CITY OF ALBUQUERQUE

March 16, 2020

Re: Blake's Lotaburger #75
4121 Coors Blvd. NW
Traffic Circulation Layout
Architect's Stamp 03-10-20 (G11D069D)

AS-104
SHEET NO. 104 OF 104 SHEETS

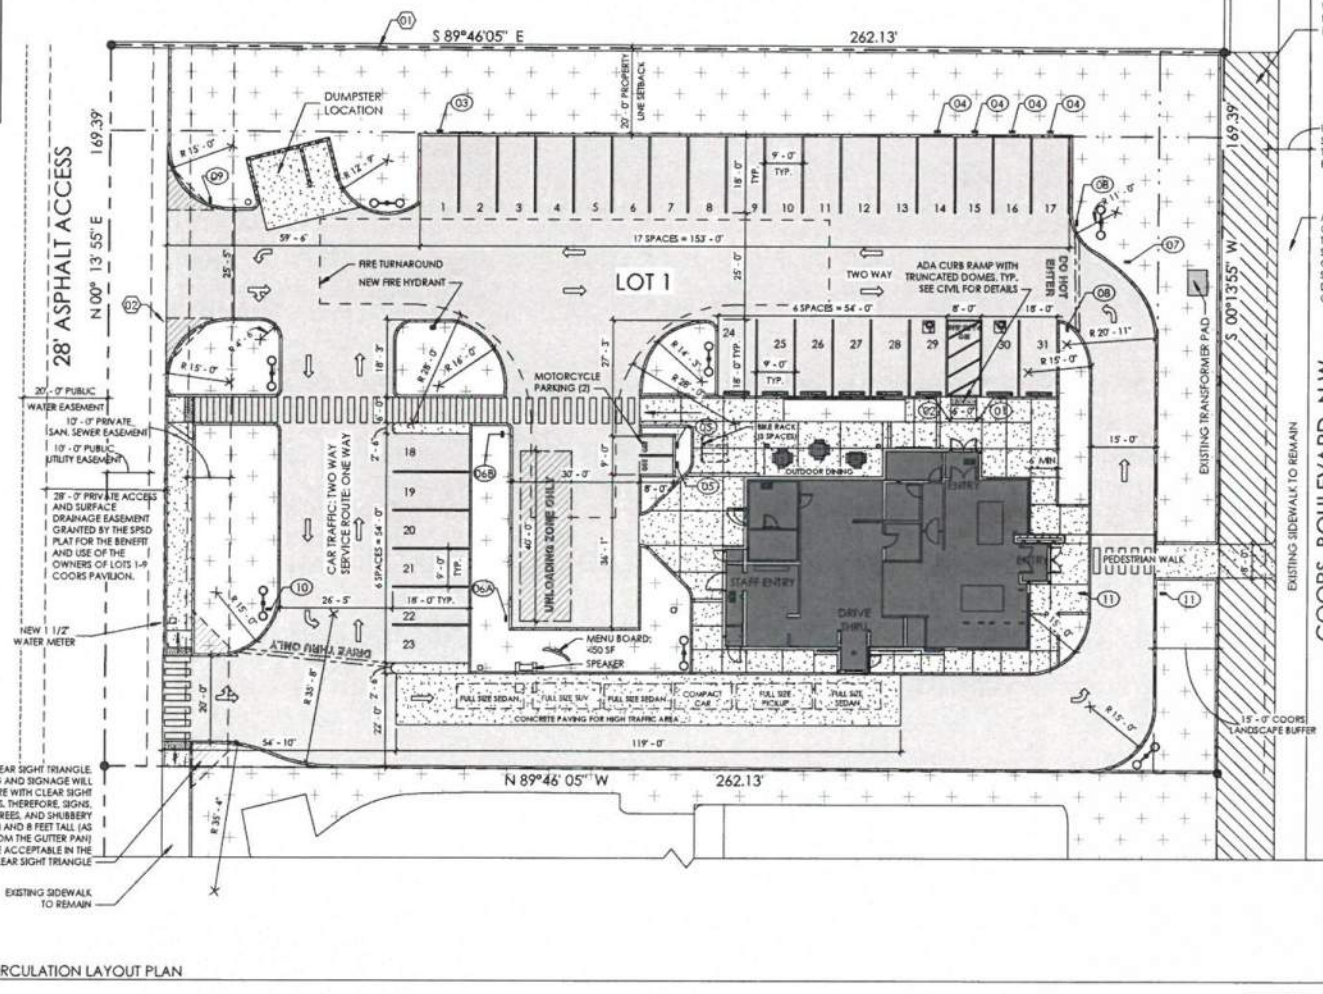
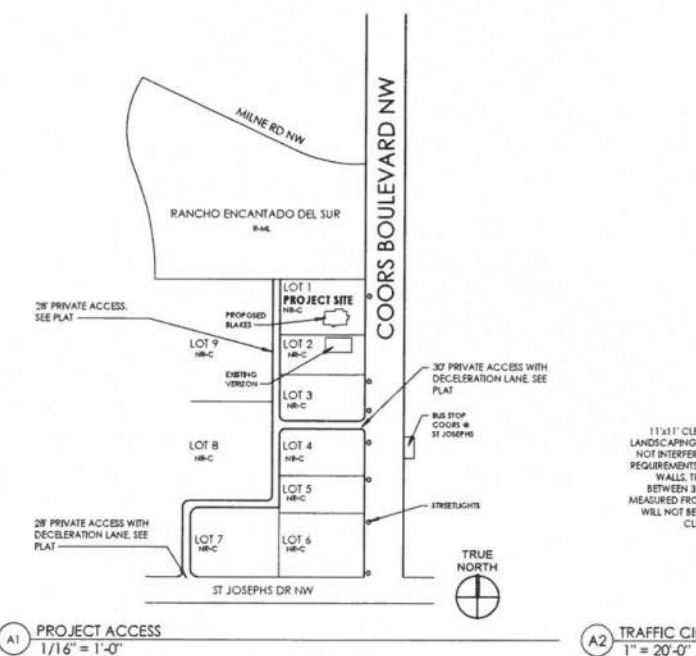
9. ADA curb ramps must be updated to current standards and have truncated domes installed. Provide details of all proposed ramps.
10. Motorcycle parking spaces shall be designated by its own conspicuously posted upright sign, either free-standing or wall mounted per the zoning code. Label MC on pavement.

20. ADA accessible pedestrian pathway should not be placed behind parking space or adjacent to a vehicular way. Vehicle and pedestrian/wheel chair conflicts should be avoided as much as possible.

23. For all proposed pavement markings and signage please show detail.
24. The minimum drive through lane width is 12 feet with a 25 foot minimum radius (inside edge) for all turns. (A 15 foot radius can be used with an increase in lane width to 14 feet). Please dimension all lane widths and radii.

25. Please provide a clear sight distance exhibit for southern entrance.
26. Show the clear sight triangle and add the following note to the plan:
"Landscaping and signage will not interfere with clear sight requirements. Therefore, signs, walls, trees, and shrubbery between 3 and 8 feet tall (as measured from the gutter pan) will not be acceptable in the clear sight triangle.

32. Southern Entrance: Please zero curbing at sidewalk/ramp connection.
